Subject: RE: 3421 - 55-57 River Road - EA FRA response Ref HA/2020/122604/01-L01

Please scan against LU/247/20/PL as a consultee response

In response EA concerns please find below our response, all section reference is to our Flood Risk Assessment Rev P7 14.09.20

DRAWING NO: 1908_P_302 REVISION 01

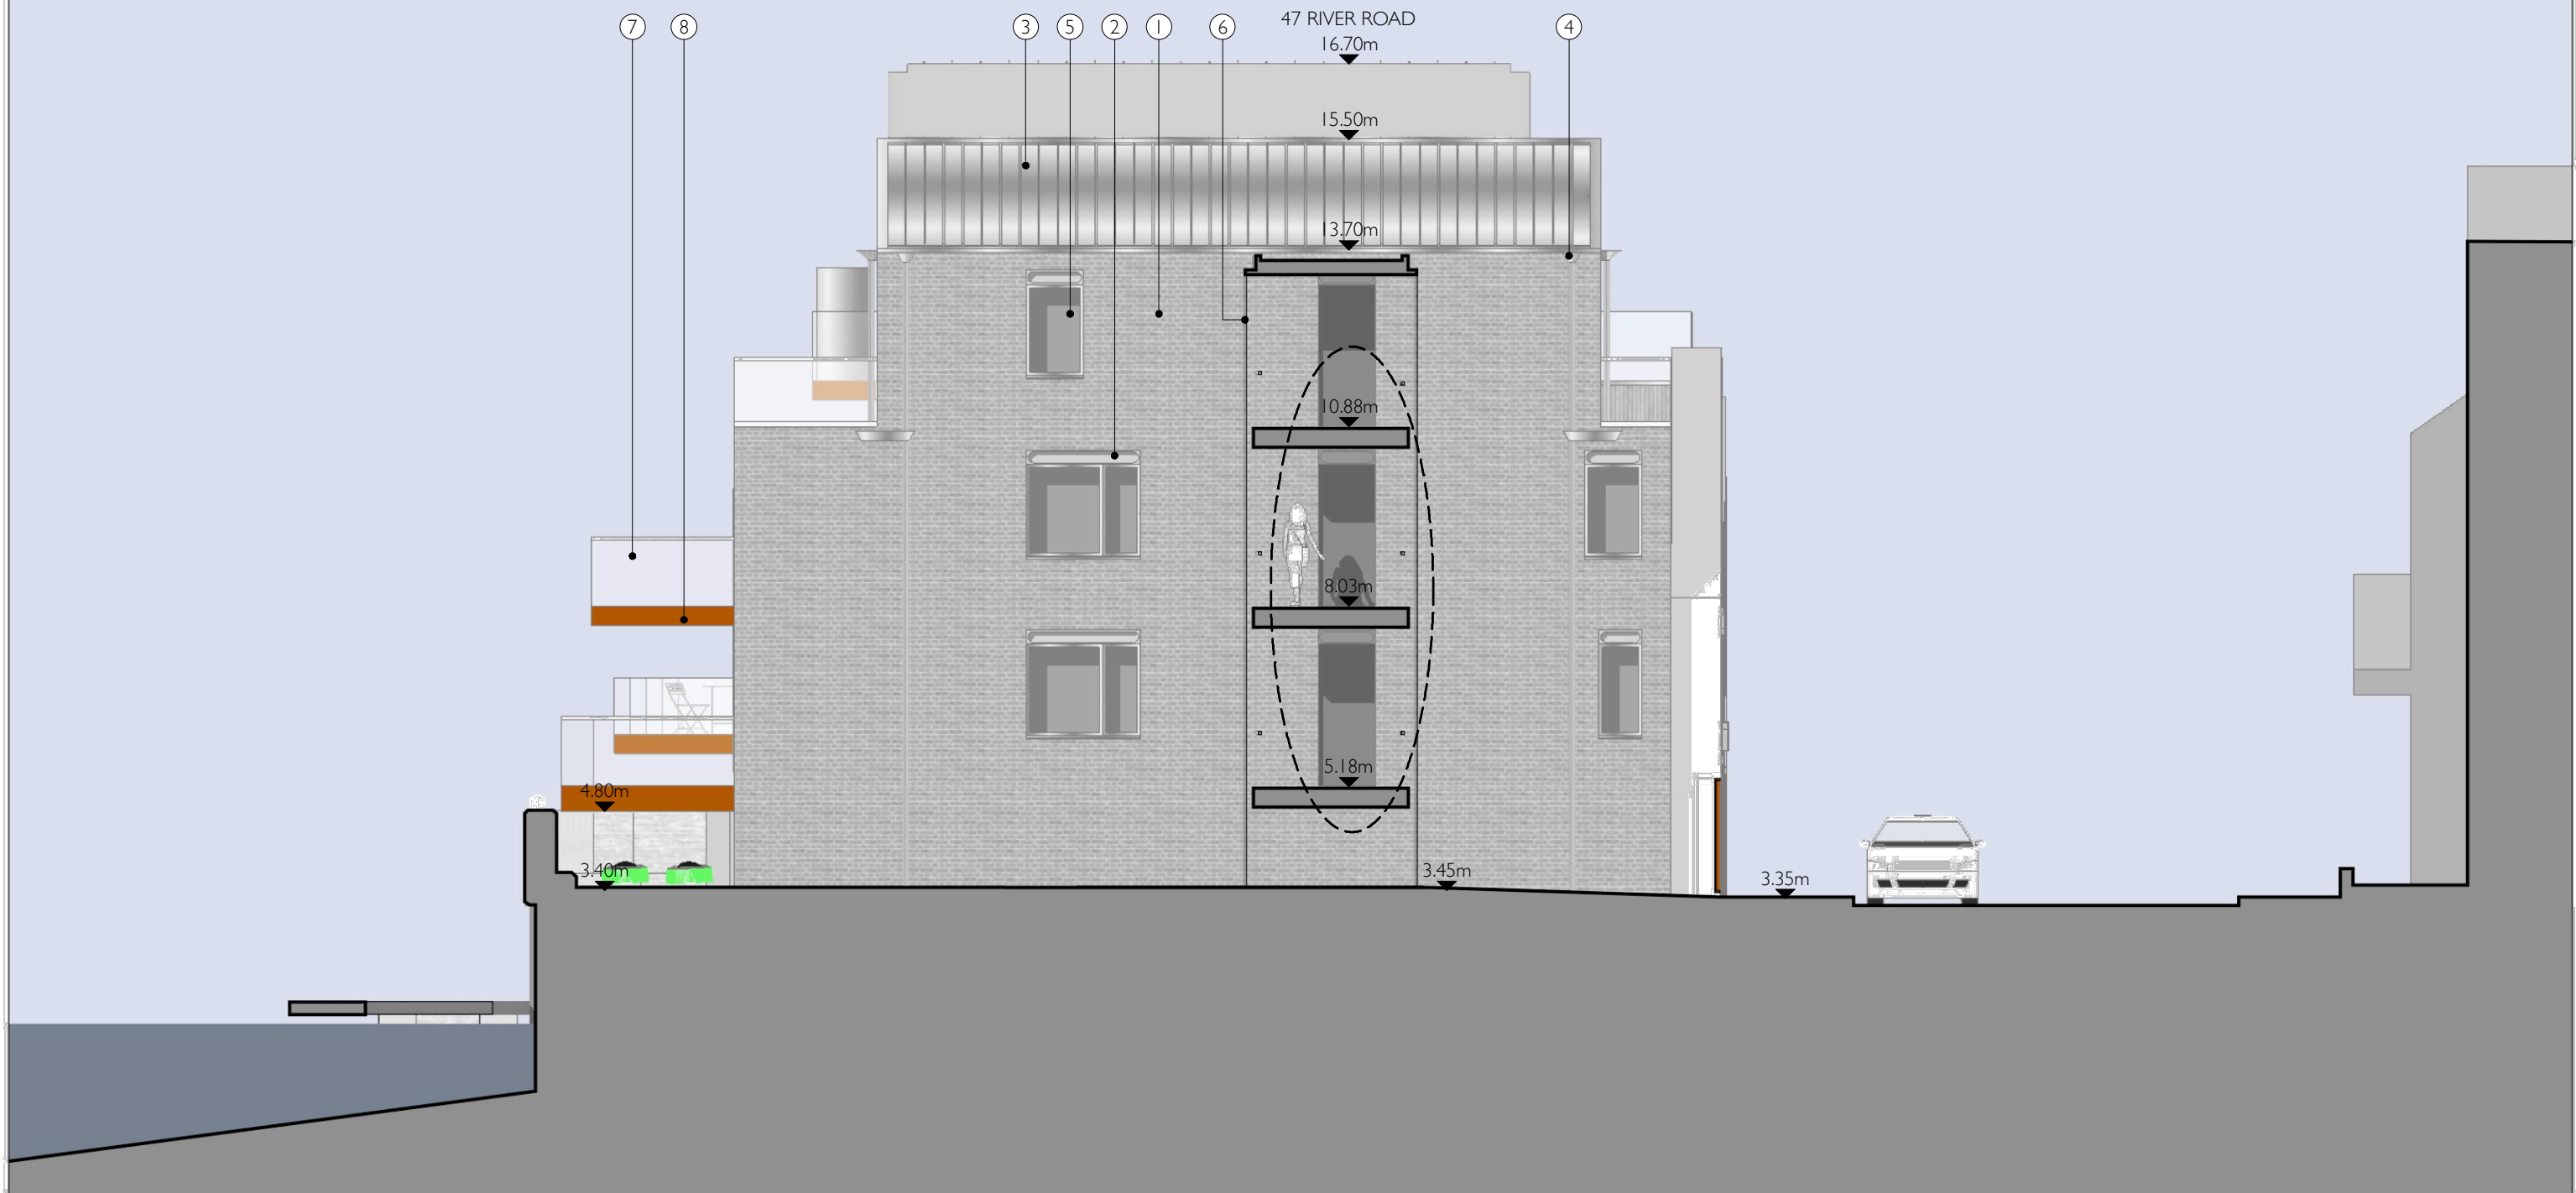
Just to clarify we agree with the methodology of your FRA, however the data from the EA which you included in your FRA appendix, for which you base the levels on, is from 2013 which is somewhat out of date. As per my response (Advice to Local Planning Authority/Applicant – Flood Data) you will need to provide an FRA with the most up-to-date data available.

- Assess finished floor levels for the dwelling against the site specific tidal flood levels (including climate change) and include sufficient freeboard; please refer to section 8.1 paragraph 3, we have taken climate change into account. The dwelling is protected for 1:200 year AEP plus climate change 4.83 mAOD plus 300mm freeboard, 5.13 mAOD. All dwellings to be situated at 5.15 mAOD which takes into account of climate change and free board (5.13 mAOD)
